# CITY OF ALBUQUERQUE

March 3, 2025

**Re: Samana Apartments (6501 Bataan SW)**  
**99999 Bridge SW**  
**Traffic Circulation Layout**  
Engineer's/Architect's Stamp 2-20-25 (L11D072)

DRAWING TITLE
TRAFFIC CIRCULATION LAYOUT

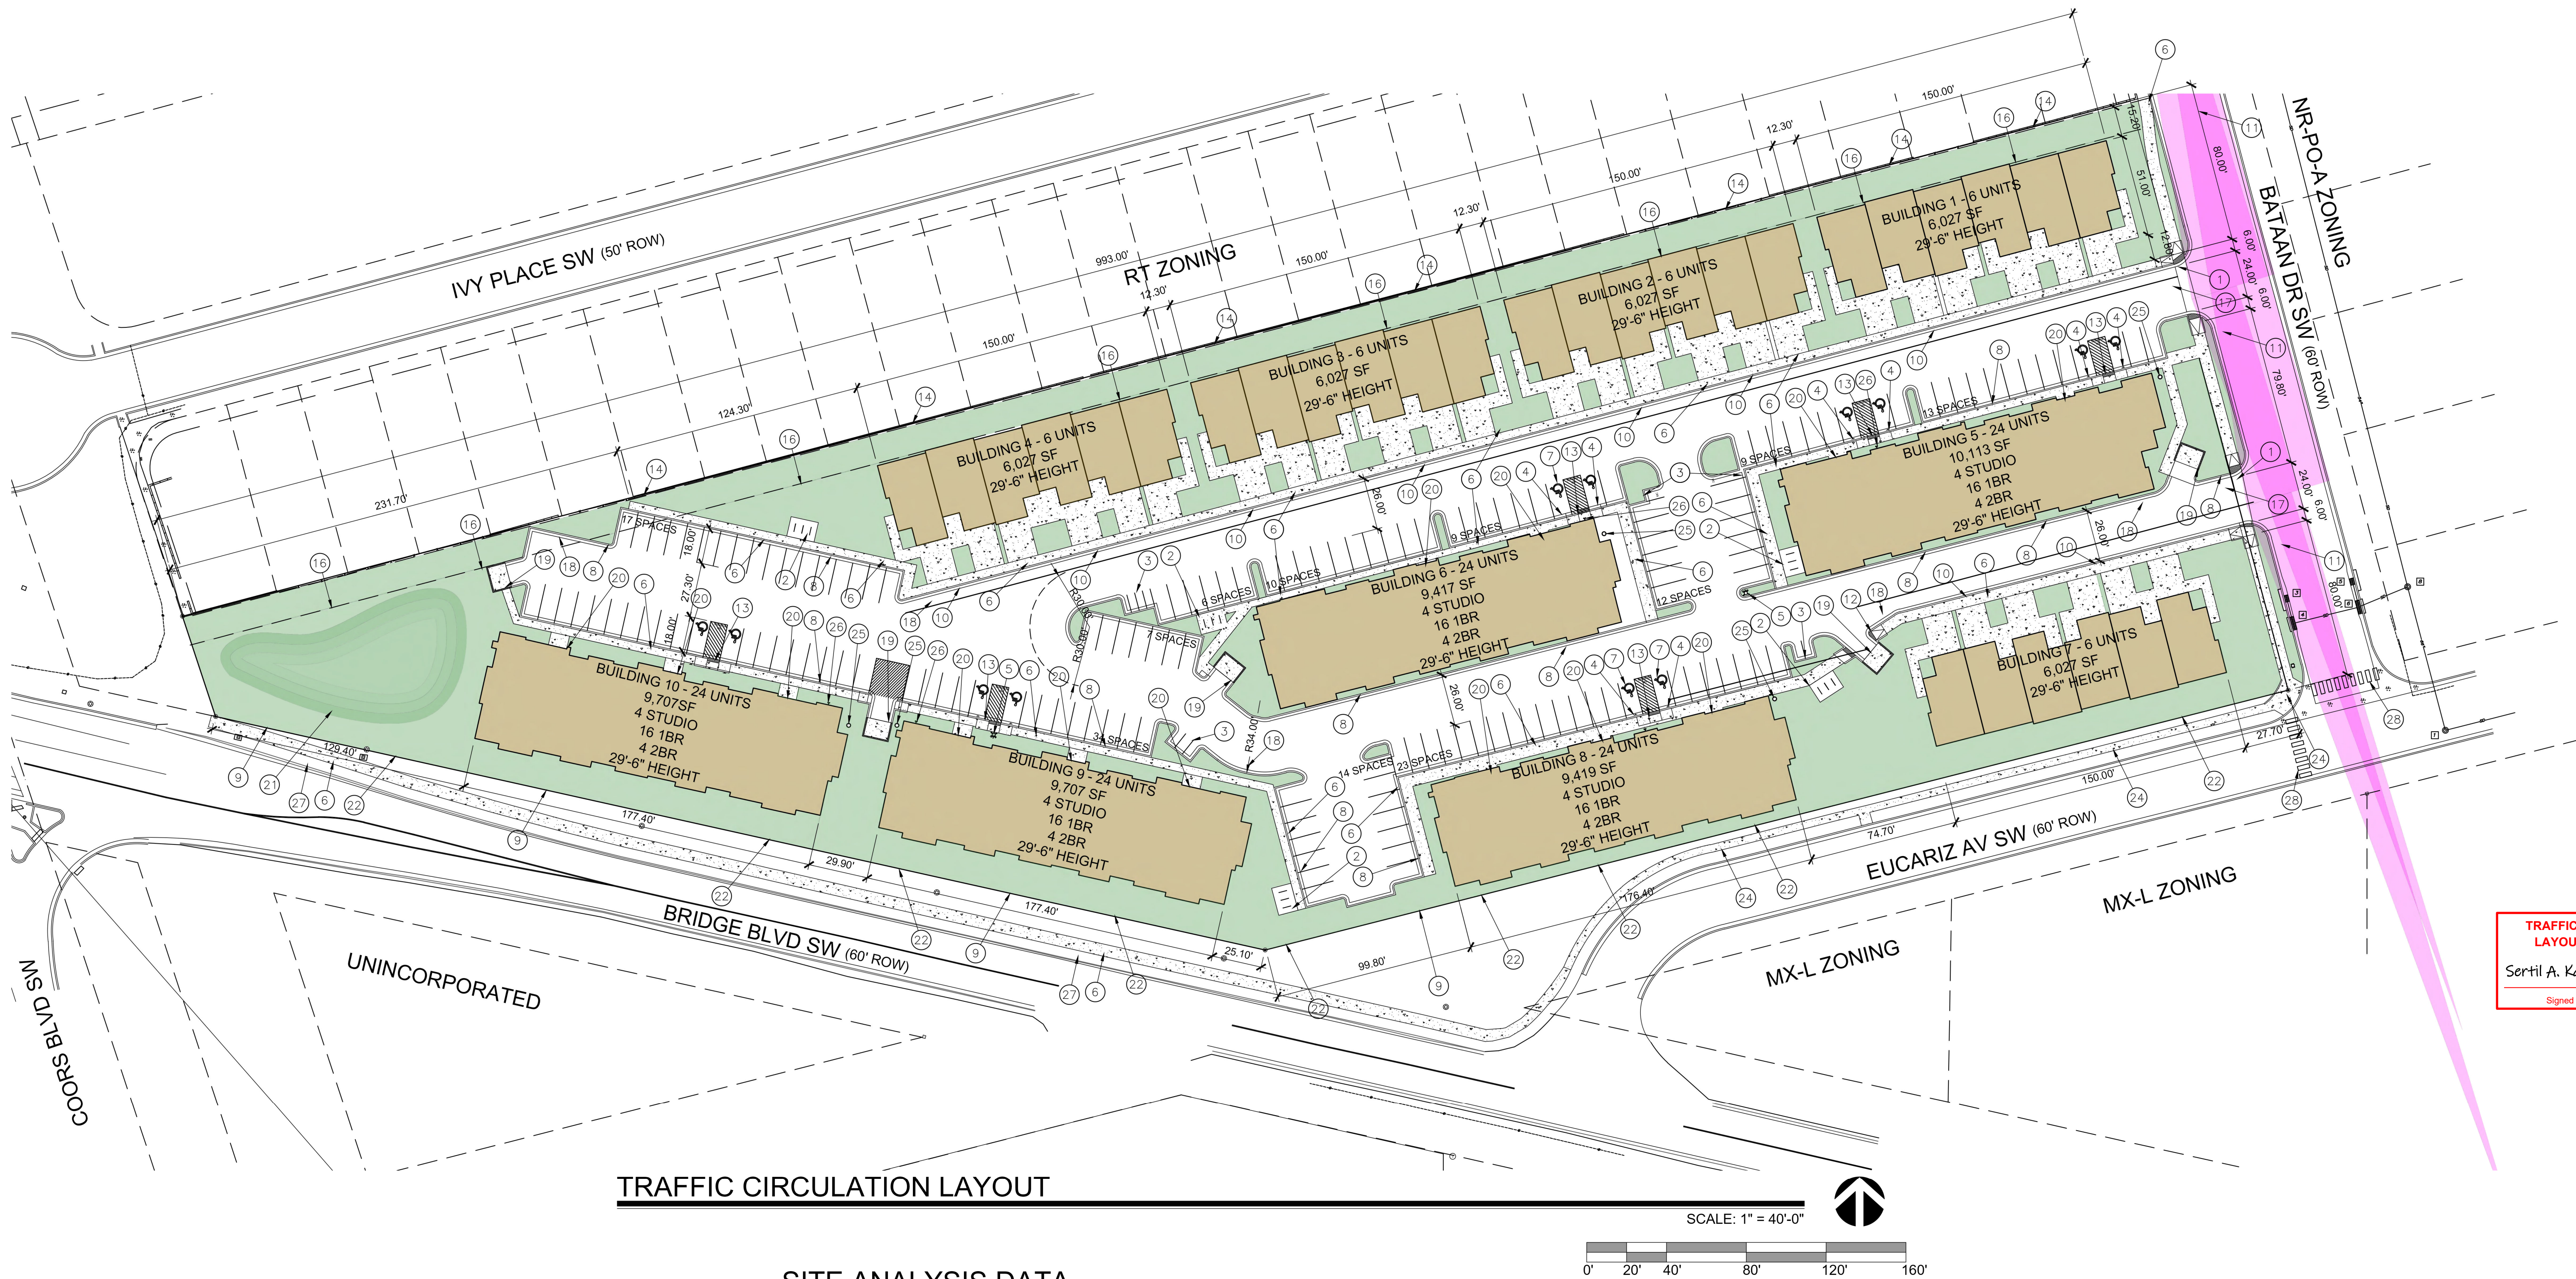
1. The traffic circulation layout must be stamped, signed, and dated by an engineer or architect licensed in the state of New Mexico. Remove the strange dots on the Stamp and other places.

2-Show the Airport Dr., ROW, and widths of sidewalk and Buffer/Landscape zone.

3-Correct the name of this road to Bridge

4-Show the widths of sidewalk, and Buffer/Landscap zone on all the four roads.

Bridge Blv requires 6' sidewalk and 5-6' Buffer/Landscape zone. Other three roads require 5' sidewalk and 5' Buffer/Landscape zone.

5-Add cross walkings with warning surface

8-Replace the sheet title to TCL-Plan instead of Site Plan

DRAWING TITLE		
SITE DETAILS		
DESIGNED	PROJECT NO	A-501
DRAWN	SCALE	
CHECKED	DRAWING NO	
REVIEWED	DATE	
DATE	5/1/2025

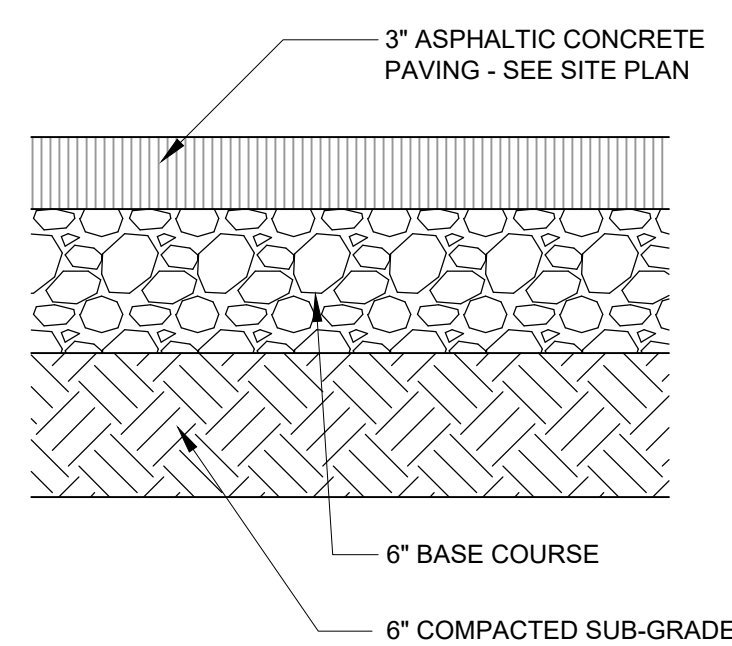
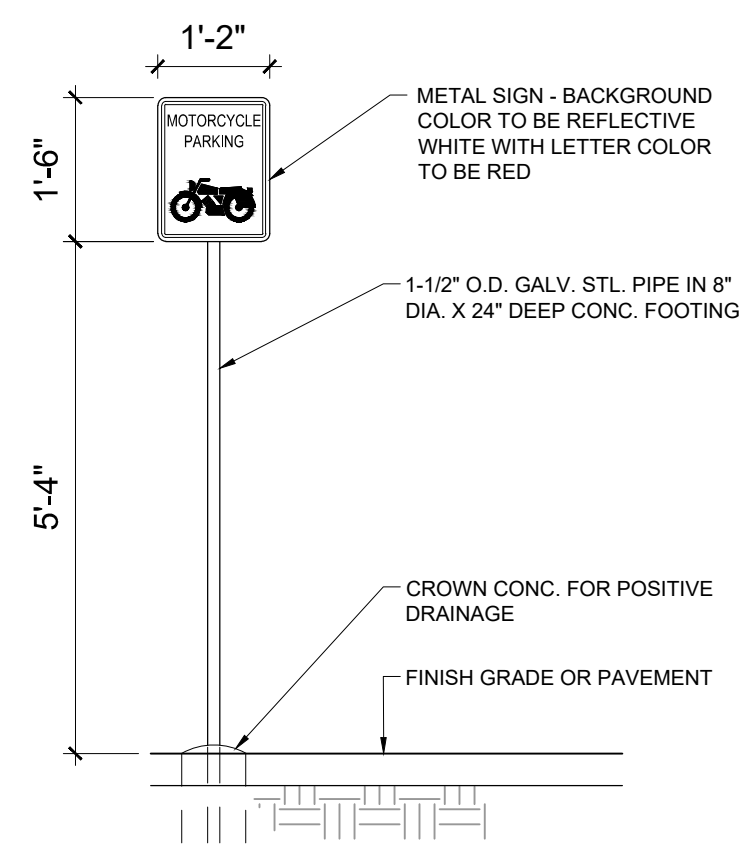
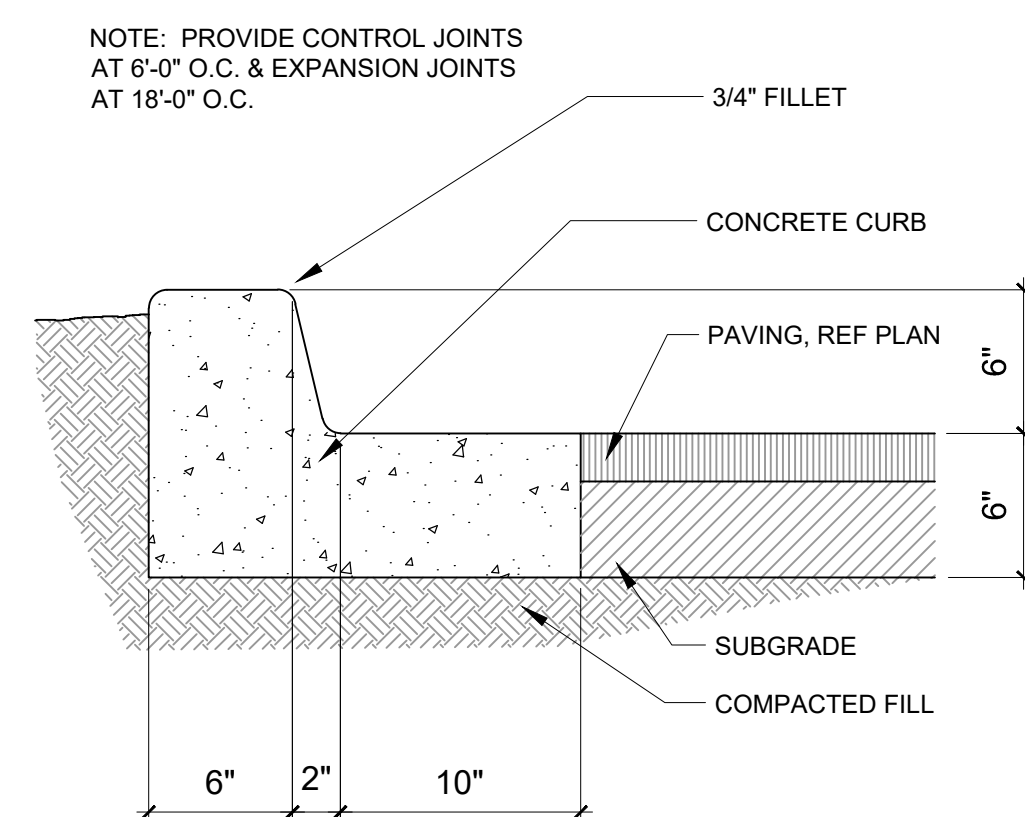
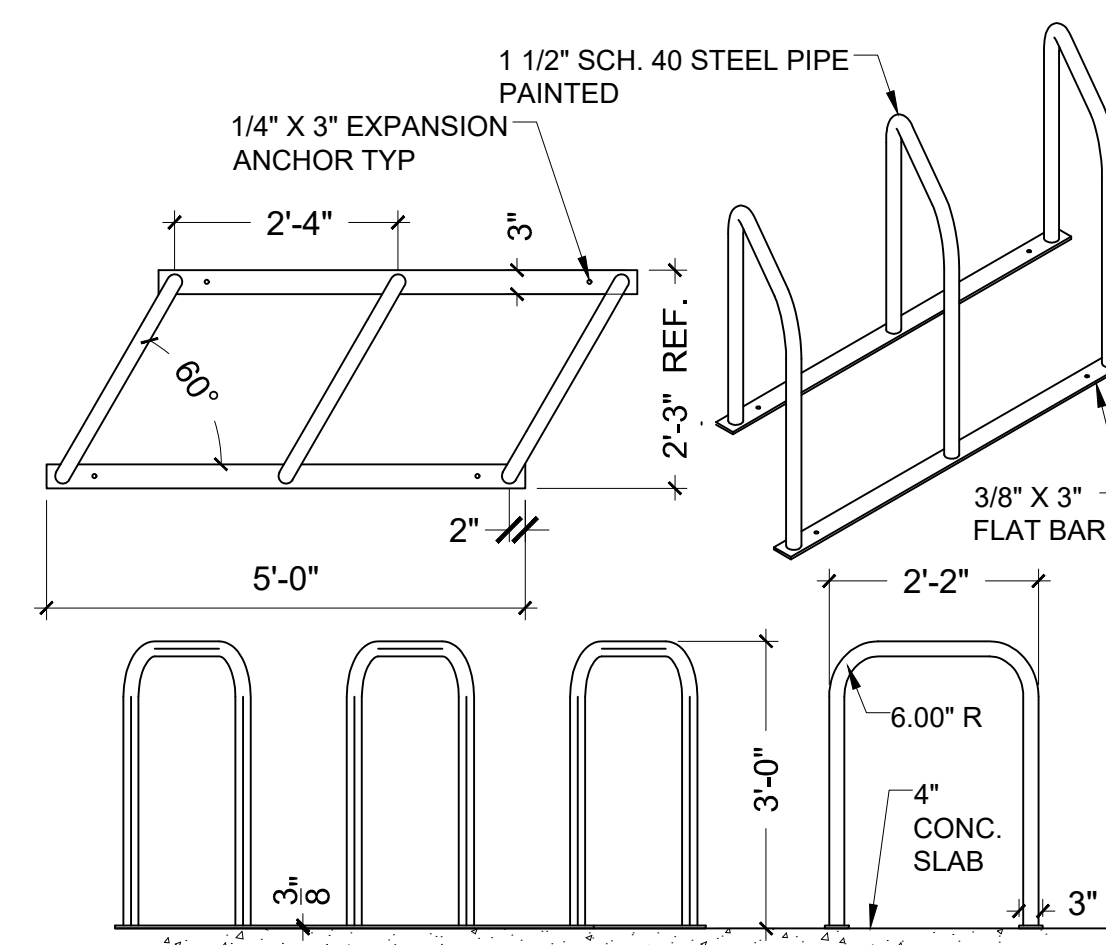
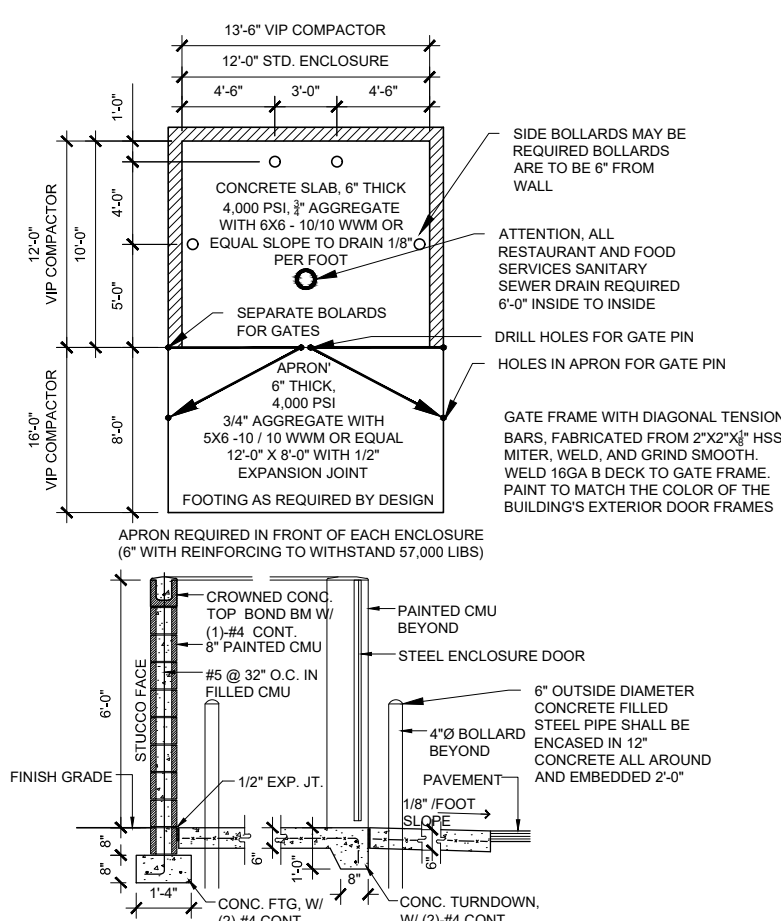
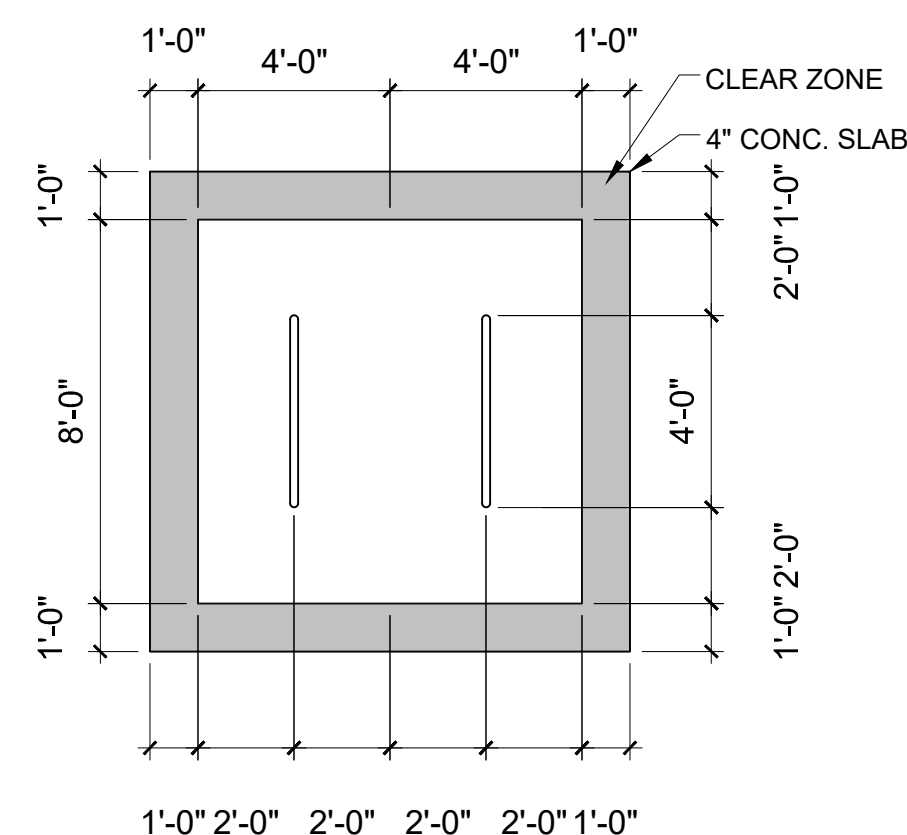
6-Add a details sheet for signages, stripings, bike racks, ADA parkings detail, and other details.

7-No details are shown

- 2. 6 SPACE BIKE RACK, REF DETAIL THIS SHEET
- 3. MOTORCYCLE PARKING SIGN REF DETAIL THIS SHEET
- 4. H.C. PARKING SIGN, REF DETAIL ON THIS SHEET
